Jeanie Bourke - Re: Urban Farm meeting 184 Anderson

From: Jesse Thompson <jesse@kaplanthompson.com>
To: Jeanie Bourke <JMB@portlandmaine.gov>
Date: 12/3/2014 11:22 AM
Subject: Re: Urban Farm meeting 184 Anderson
CC: Eli Cayer <urbanfarmfermentory@gmail.com>
Attachments: UFF-20141203-PERMIT.pdf

Revised plans per the comments below.

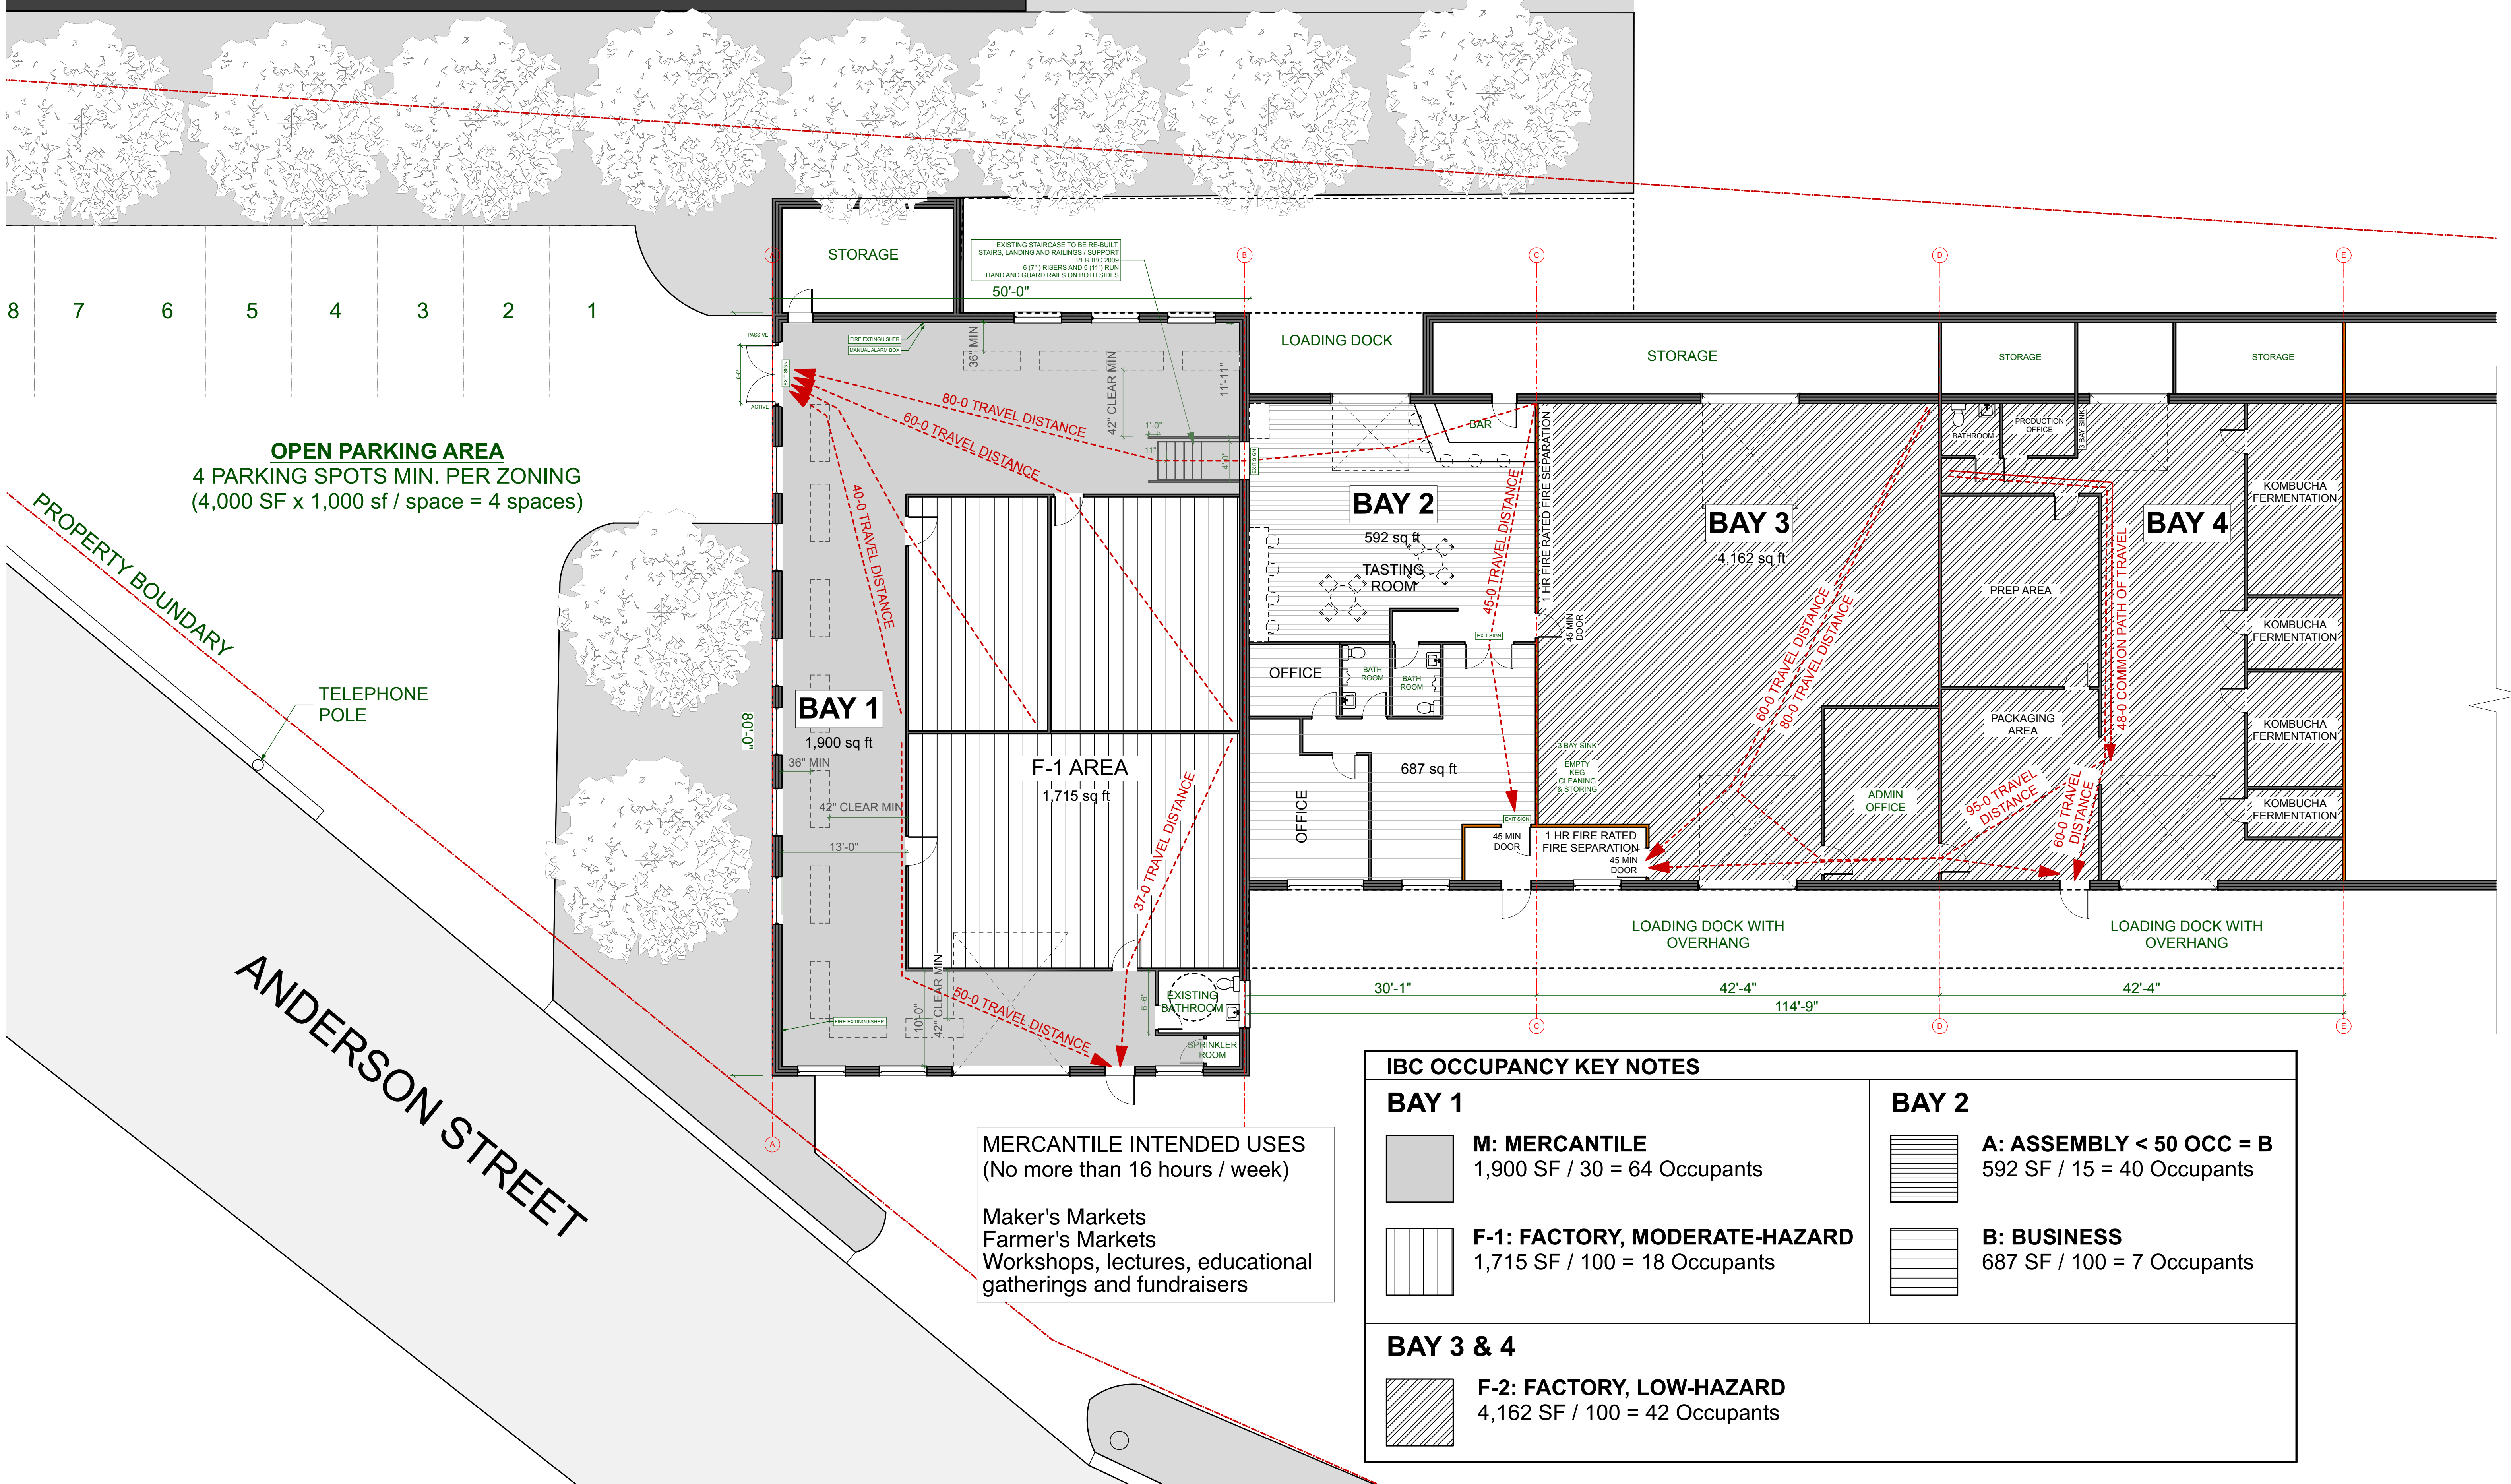
1. Occupancy counts updated to reflect IBC & NFPA on plans and tables.
2. Head of Wall diagram re-drafted for better clarity.
3. NFPA key notes added to A1.1
4. Guard railing on loading dock raised to 42" to cover all circumstances.
